PLAN VIEW 2
SCALE 1:250

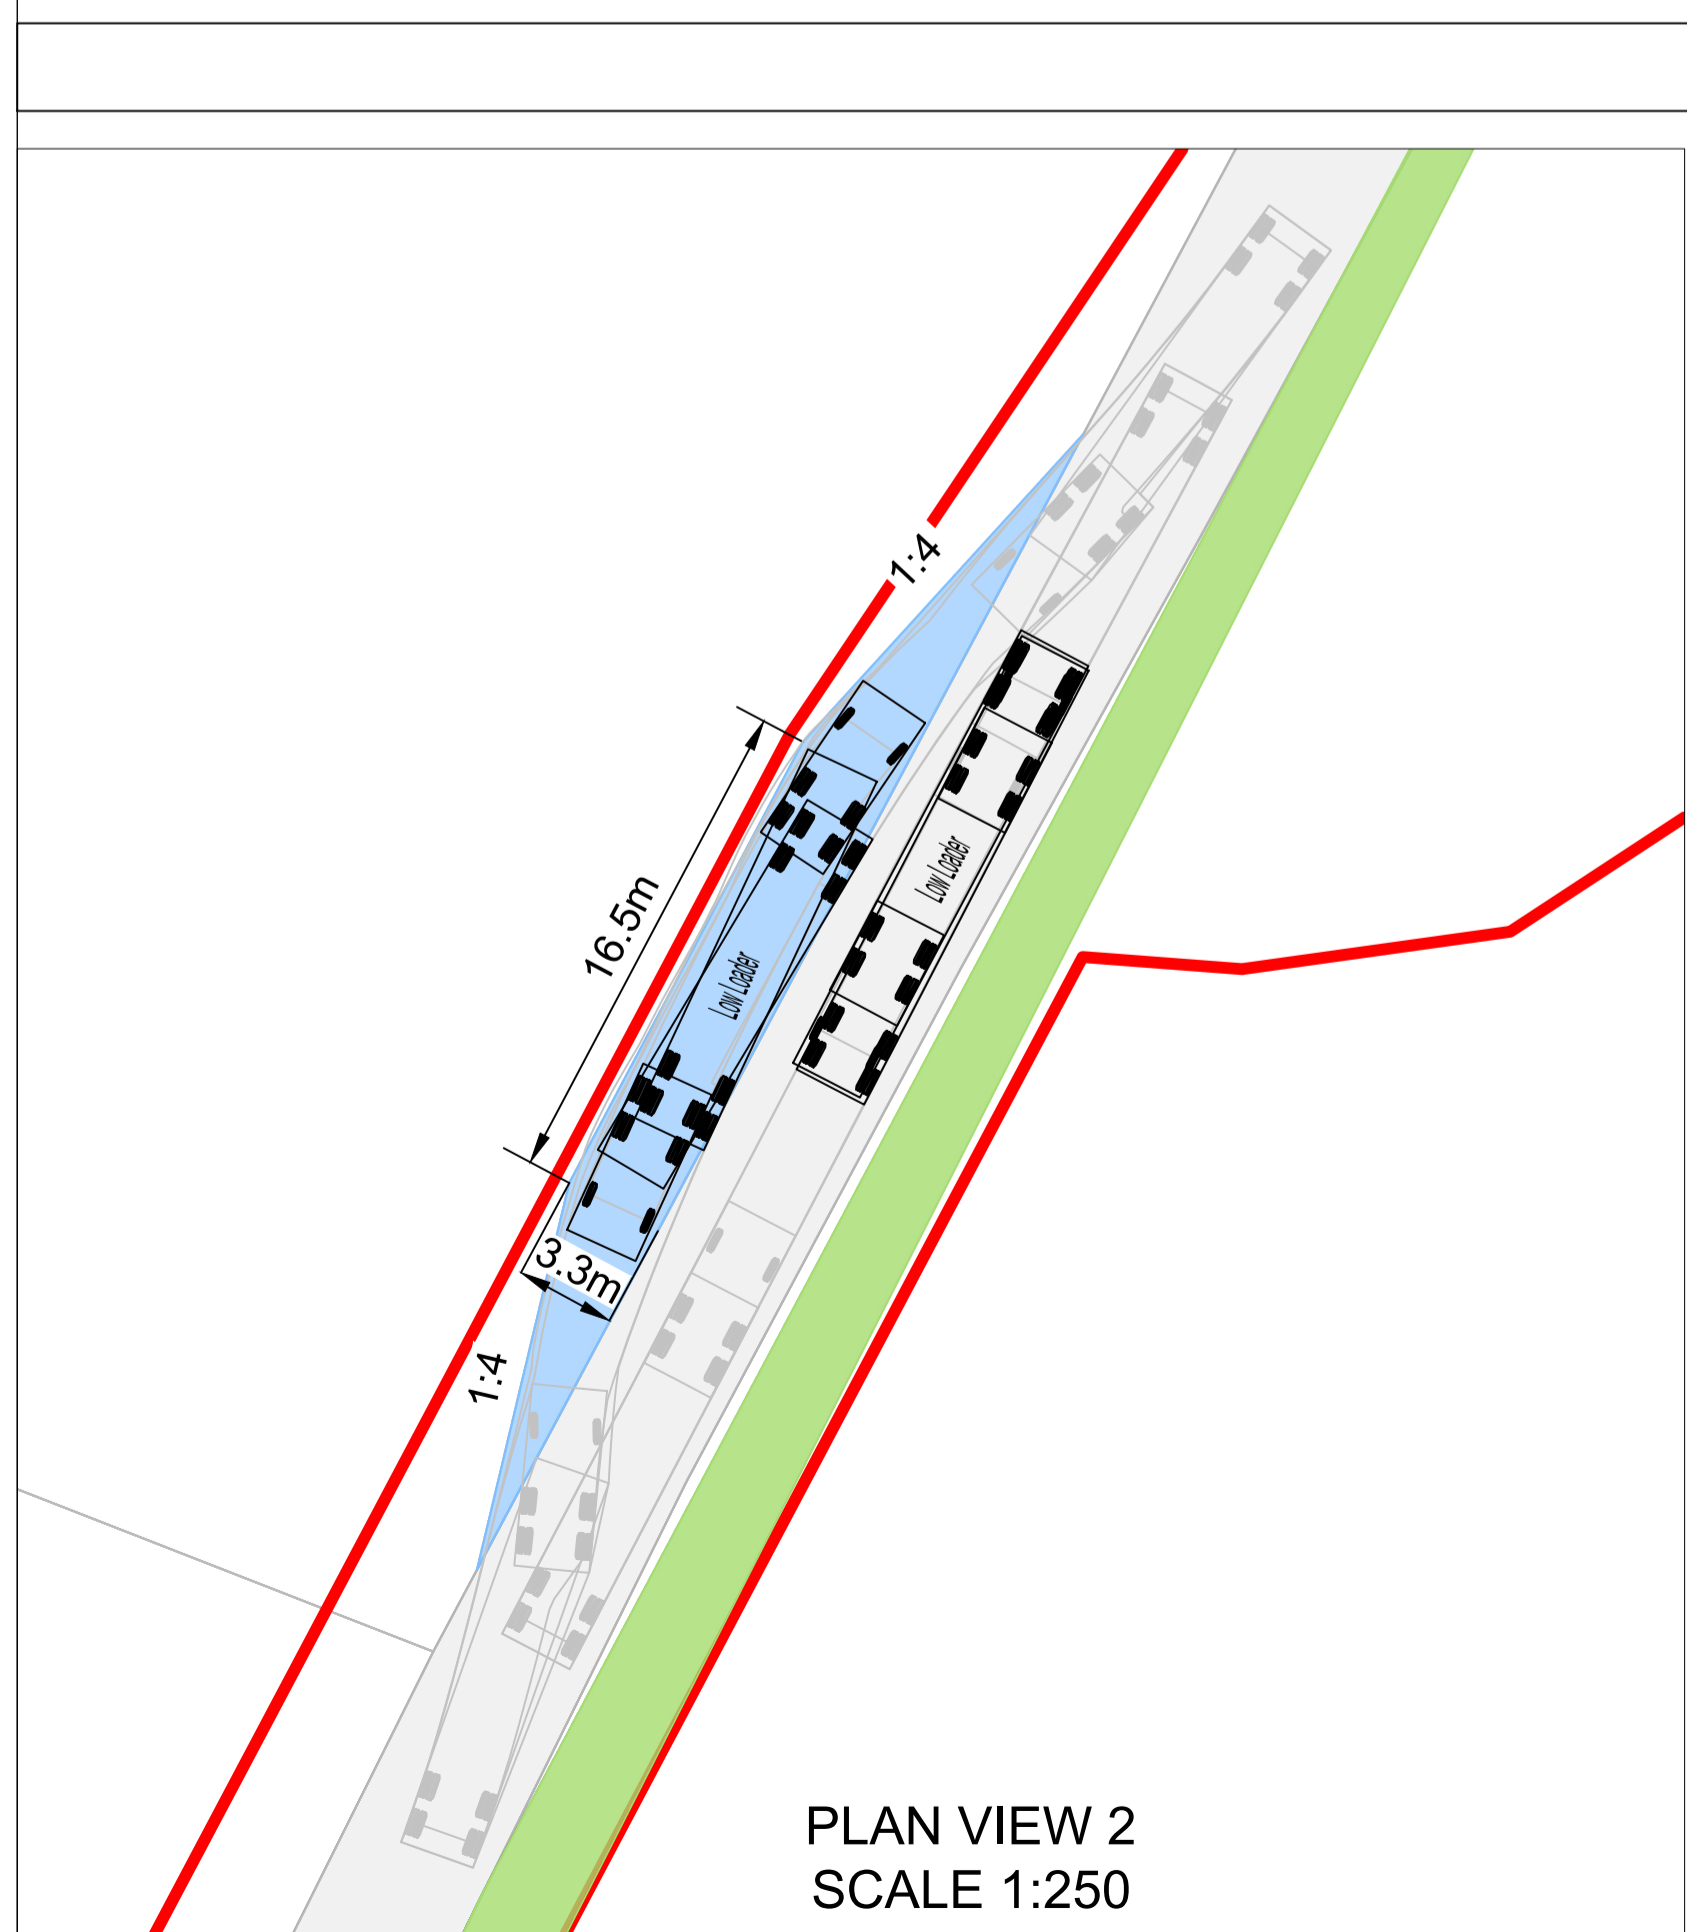
1.3.2	<p>Illustrative Plan: SP005 Access During Construction Phase [REP4-026], Appendix D a) Is this the level of detail that you would find useful post consent as part of the THPS? b) If not, what else would be of use?</p>	<p>a) Yes, in the main, subject to the inclusion of the items shown in b) b) The proposed materials to be used/ thicknesses etc shown on the plans and any new drainage/ existing drainage</p>
